RE: Major Projects – SEARs Request – Leppington Civic Centre at 173-183 Rickard Road, Leppington (SSD-99319962)

Below is a summary of the points discussed at the meeting and additional comments that form Camden Council's response to the request for SEARs:

Drawing Title	BYRON ROAD - LONGITUDINAL AND TYPICAL CROSS SECTIONS			
Scale	A1 AS SHOWN	Project No.	23629	Dwg. No.
			400	Issue
				A

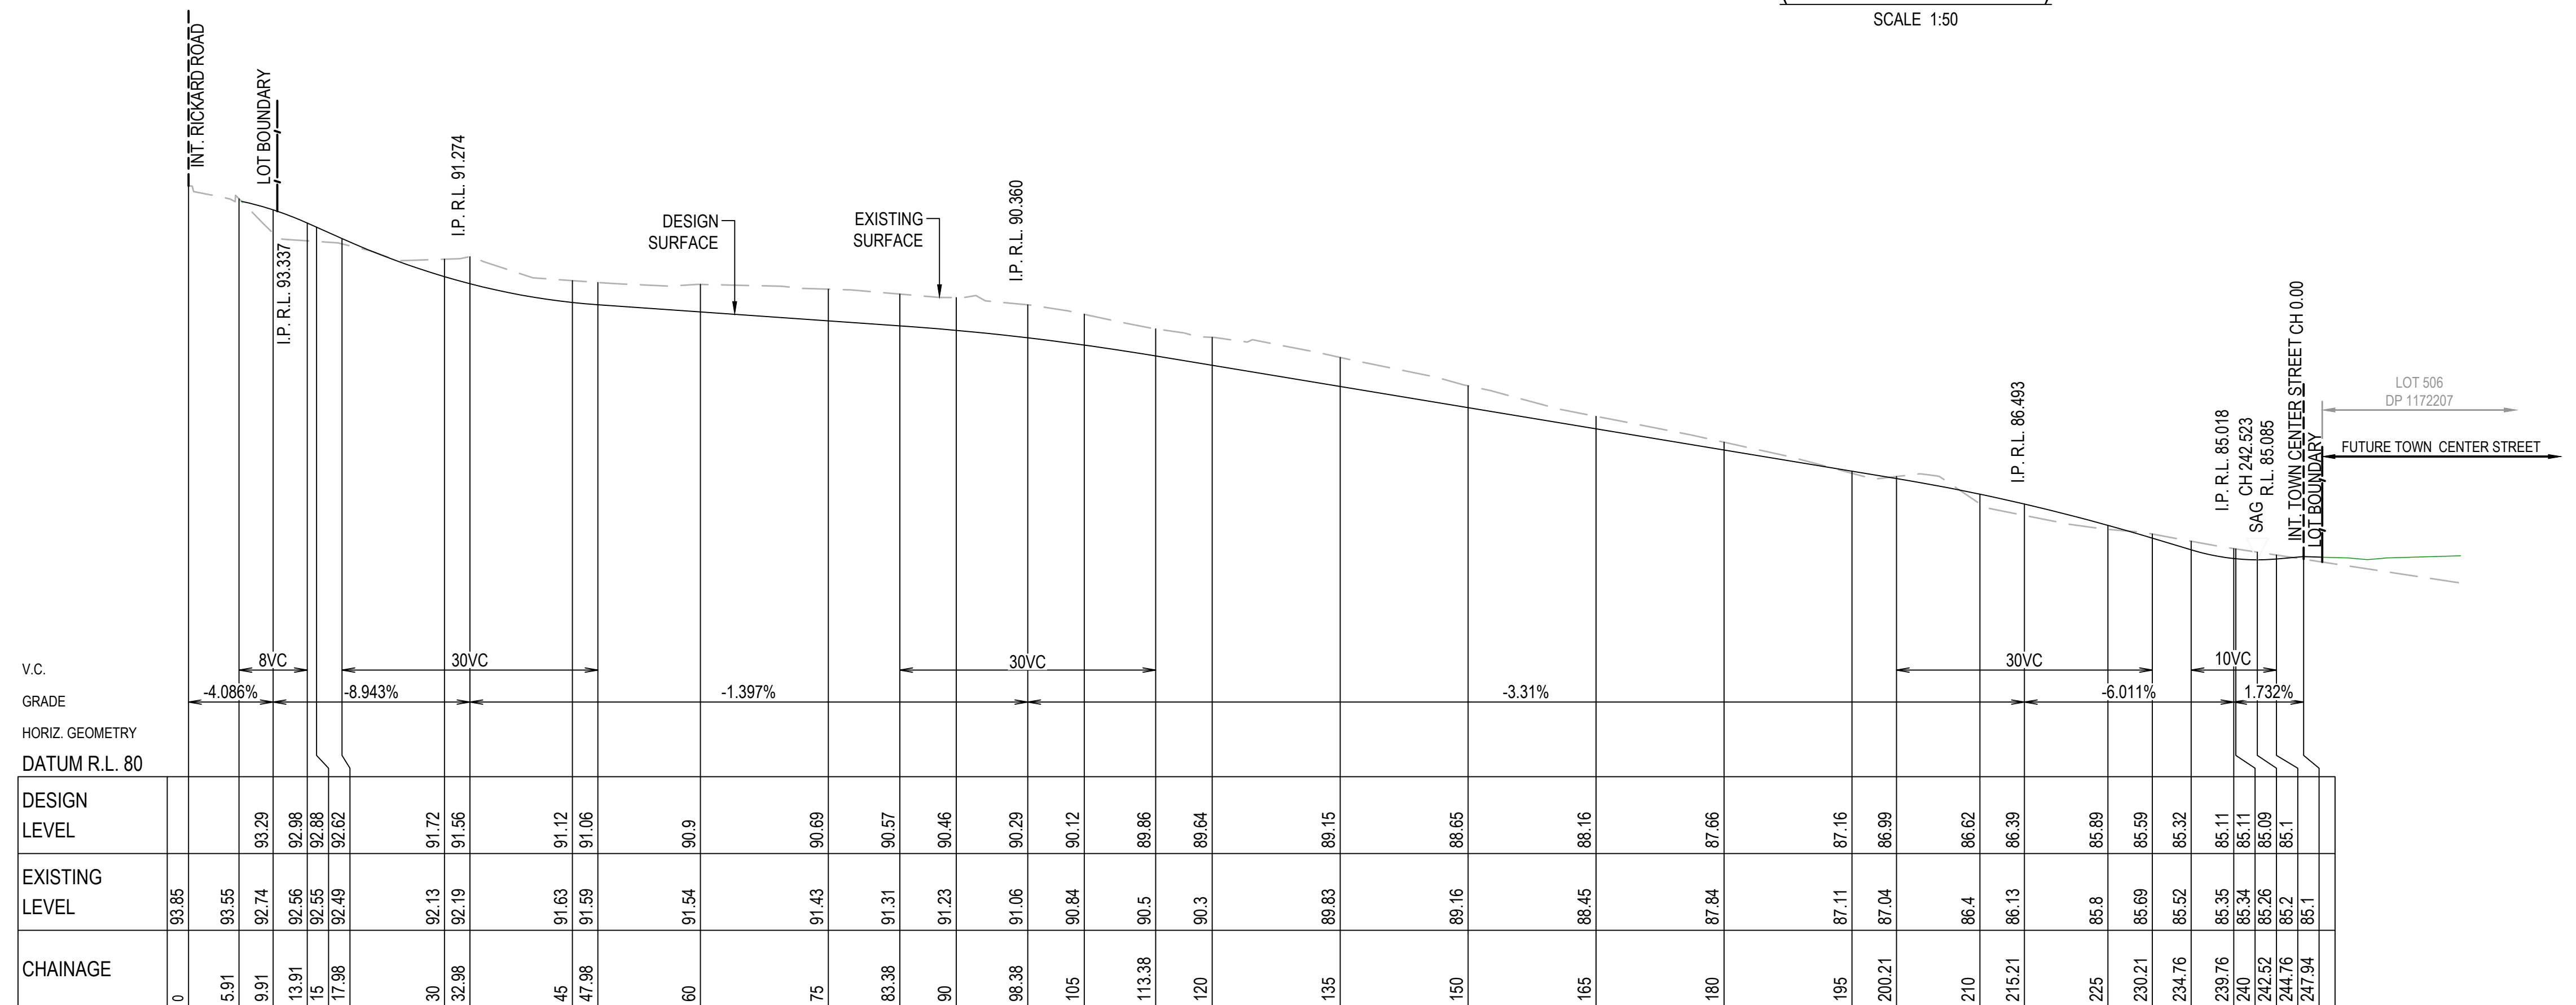
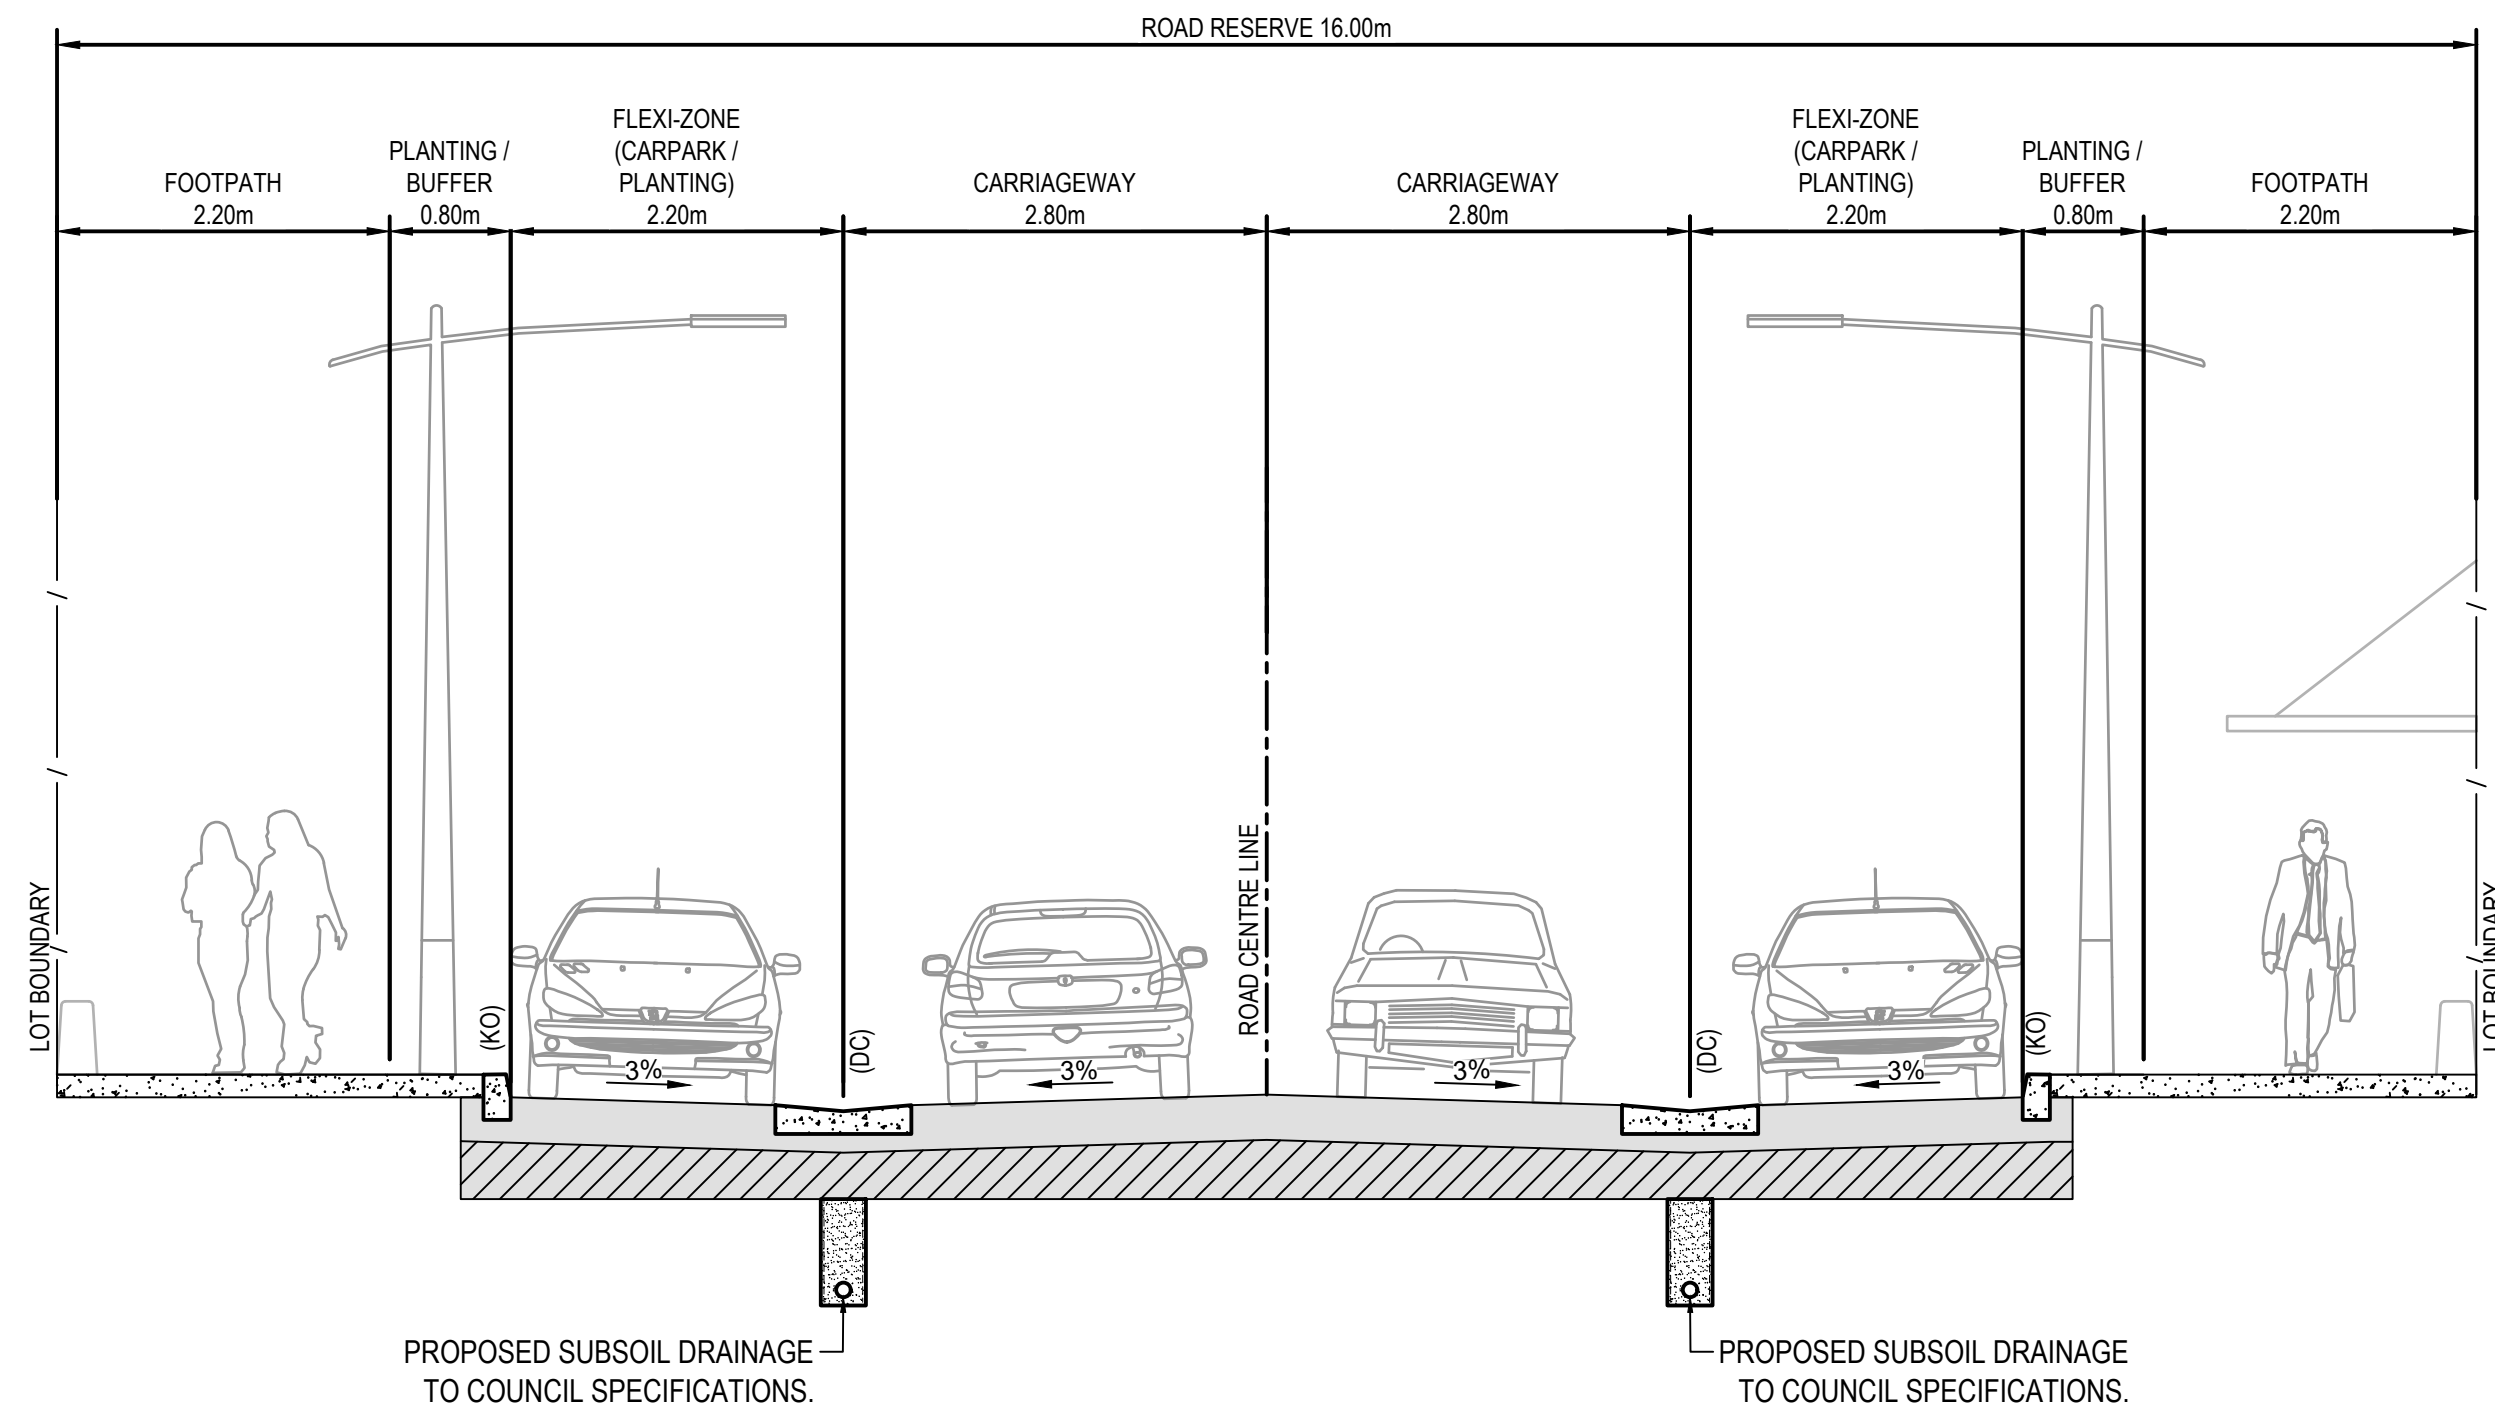
- TfNSW also raised concern with the conflict that the proposed extension of Byron Road (west of Rickard Road) would have on the existing driveway entrance to the commuter car park.

- This outcome is/was less than desirable and the completion of all public domain works, including the extension of Byron Road (west of Rickard Road), should be completed as part of any proposed development.

- The applicant should consult with TfNSW (early and ongoing) to ensure the Byron Road (west) extension is completed and access to the commuter car park is provided from this new road.

- The road geometry of the Byron Road extension (west of Rickard Road) should also align with the site specific provisions ultimately established in the finalised LTC SARP (to ensure bus access is available to the bus interchange).
